CITY OF ALBUQUERQUE

Re: Raising Cane's 4800 Montgomery Blvd. NE
Traffic Impact Analysis
HT#G17D011
Engineering Seal date 11/30/2021

Review of the Raising Cane's 4800 Montgomery Blvd. NE Traffic Impact Analysis (TIA), dated 11/30/2021, received February 15, 2022 has been completed by the City's Planning Transportation Development section. The following comments should be addressed prior to the next submittal.

- Recommended lane configuration is shown in **Figure 12**.

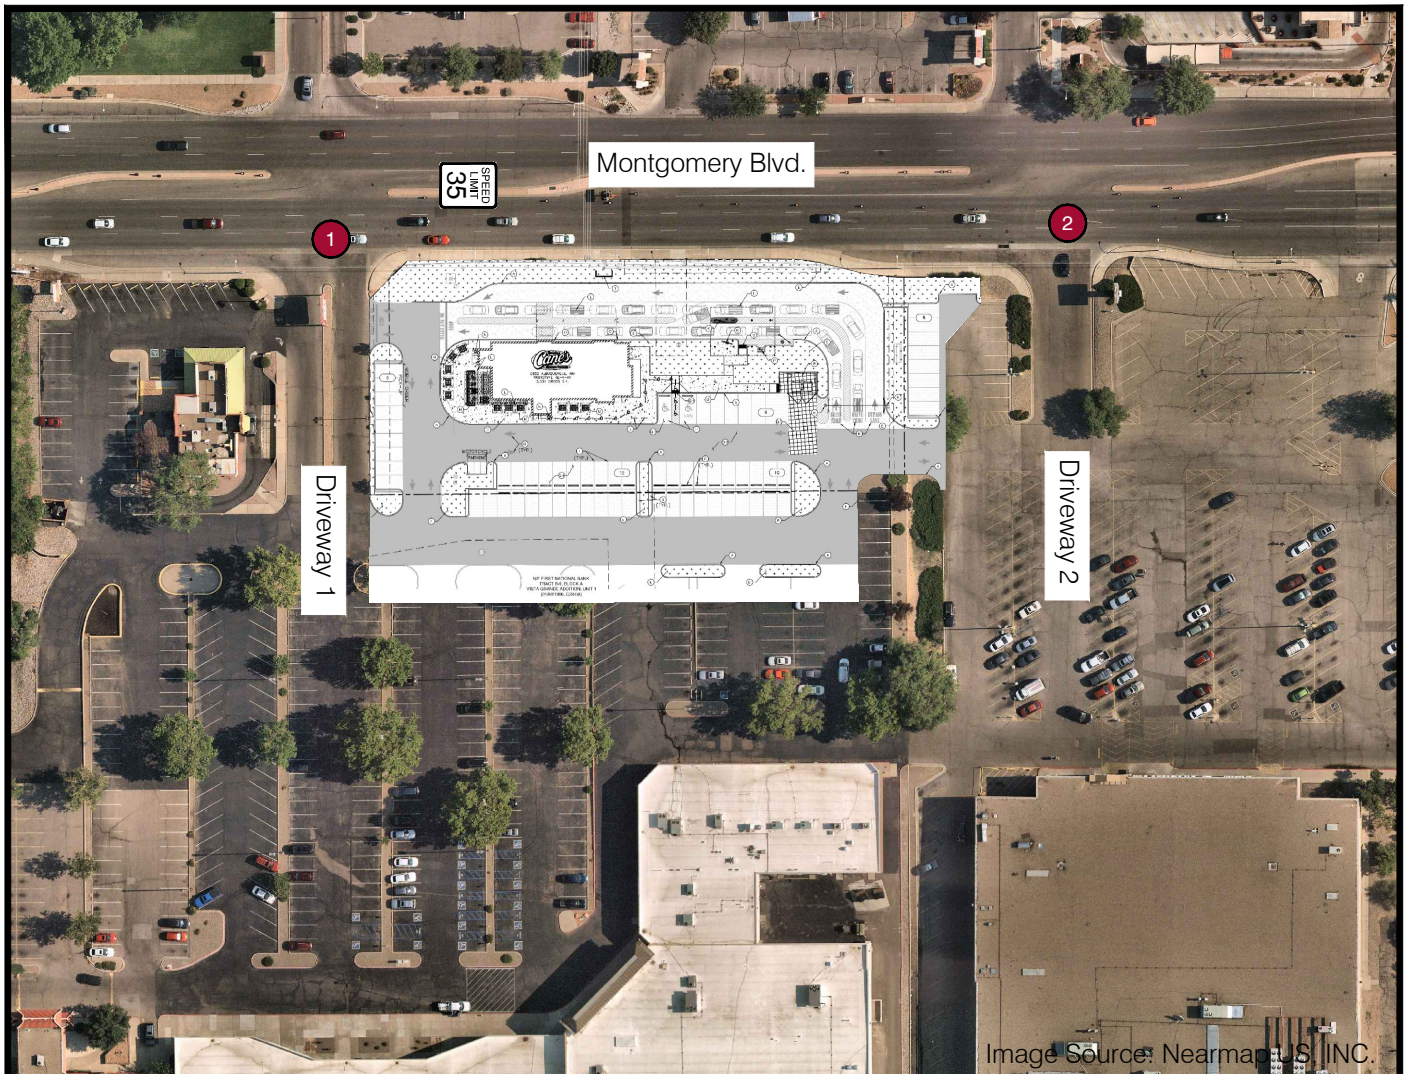
1. The northbound right-turn movement exceeds the peak hour traffic volume requirement for a right-turn lane. Driveway #1 egress should be separated into a right-turn lane and a combination left-turn/through lane. This can be accomplished by lane striping, pavement turn symbols and lane control signs.
- 2022 total Buildout, at driveway #2

2. The northbound right-turn, eastbound right-turn and westbound left-turn movements exceed the peak hour traffic volume requirement for turn lanes. Driveway #2 egress should be separated into a right-turn lane and a combination left-turn/through lane. This can be accomplished by lane striping, pavement turn symbols and lane control signs.

3. The existing eastbound right-turn lane is shorter than required in the CABQ PDM. The existing lane length should be increased. Due to the proximity of an electrical transmission tower west of driveway #2 the turn lane length would be shorter than the recommended 250 feet plus transition. It appears that a 200 feet long plus transition turn lane can be accommodated without relocation of the utility pole.

4. The existing westbound left-turn lane is shorter than the CABQ DPM requirement and is to remain as is. The existing geometry associated with this turn lane and the eastbound left-turn lane prevents increasing the westbound left-turn lane length to meet the CABQ DPM's required turn lane length.
